**EL PASO COUNTY PLANNING AND
 COMMUNITY DEVELOPMENT
 DEPARTMENT**

GRADING AND EROSION CONTROL PLAN CHECKLIST

Revised: July 2019

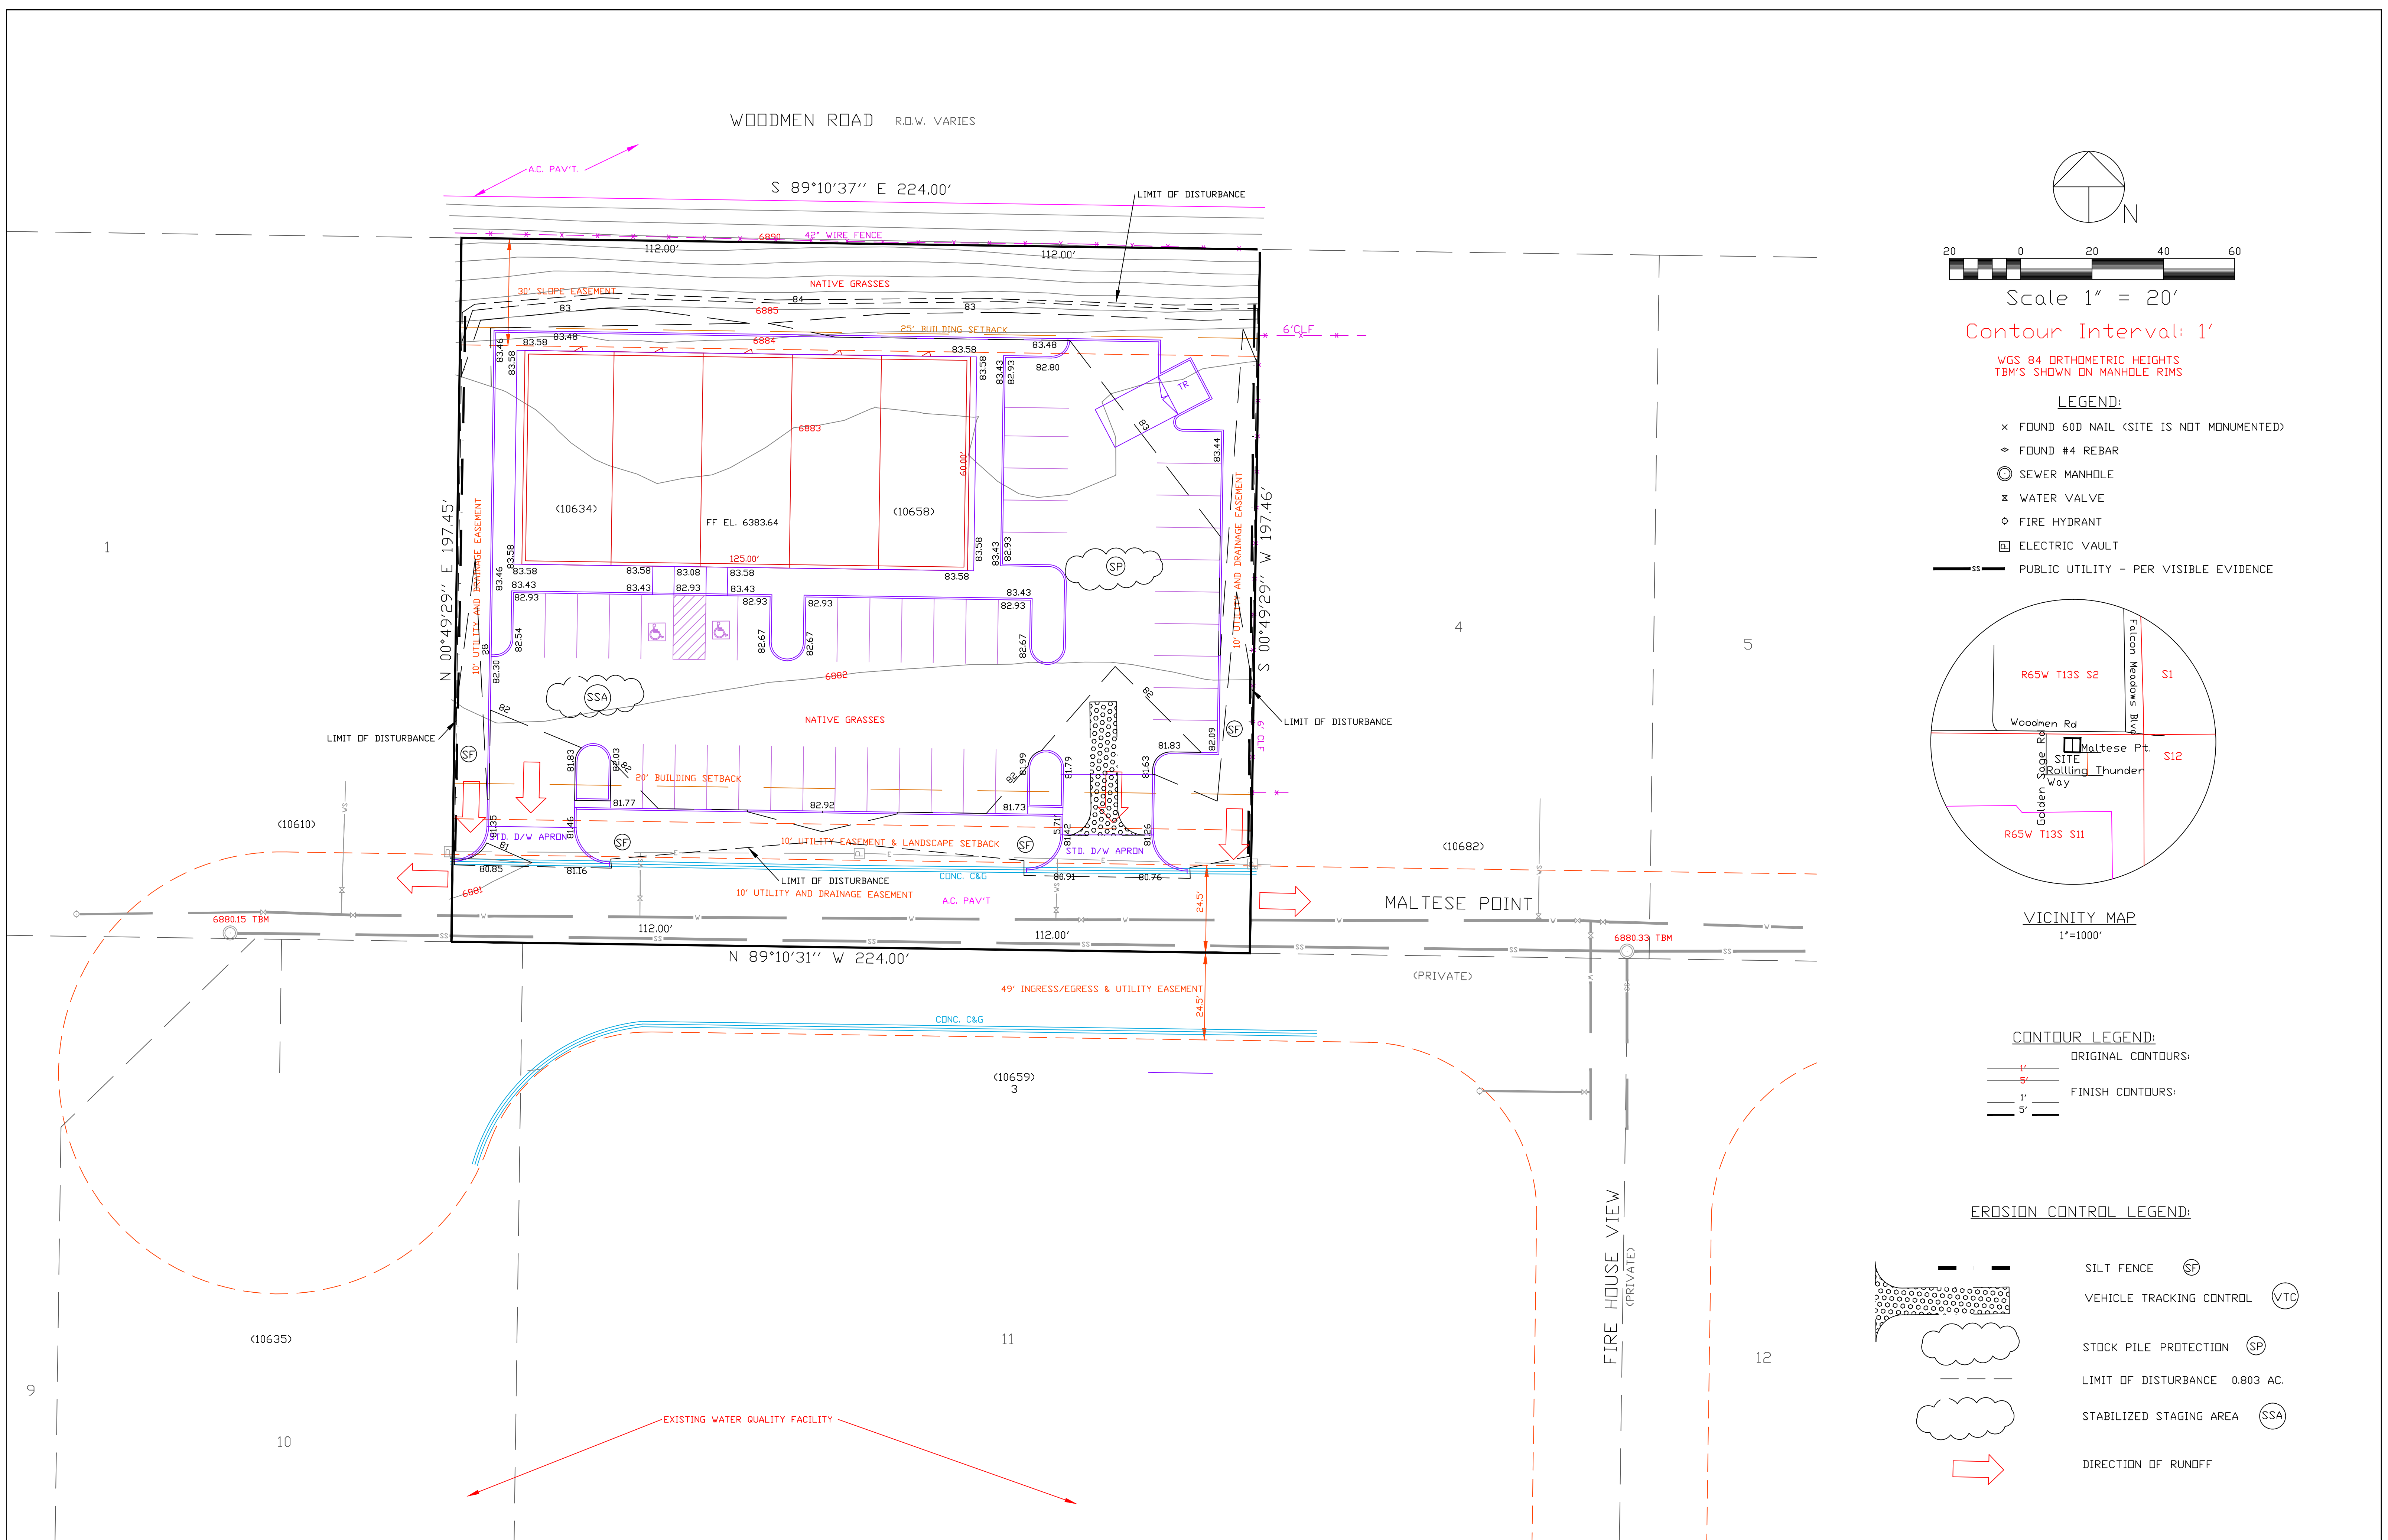
v	All proposed temporary construction control measures, structural and non-structural. Temporary construction control measures shall be identified by phase of implementation to include "initial," "interim," and "final" or shown on separate phased maps identifying each phase.	n/a	X
w	Vehicle tracking provided at all construction entrances/exits. Construction fencing, barricades, and/or signage provided at access points not to be used for construction.	x	X
x	Temporary sediment ponds provided for disturbed drainage areas greater than 1 acre.	n/a	N/A
y	Dewatering operations to include locations of diversion, pump and discharge(s) as anticipated at time of design.	n/a	N/A
z	All proposed temporary construction control measure details. Custom or other jurisdiction's details used must meet or exceed EPC standards.	n/a	X
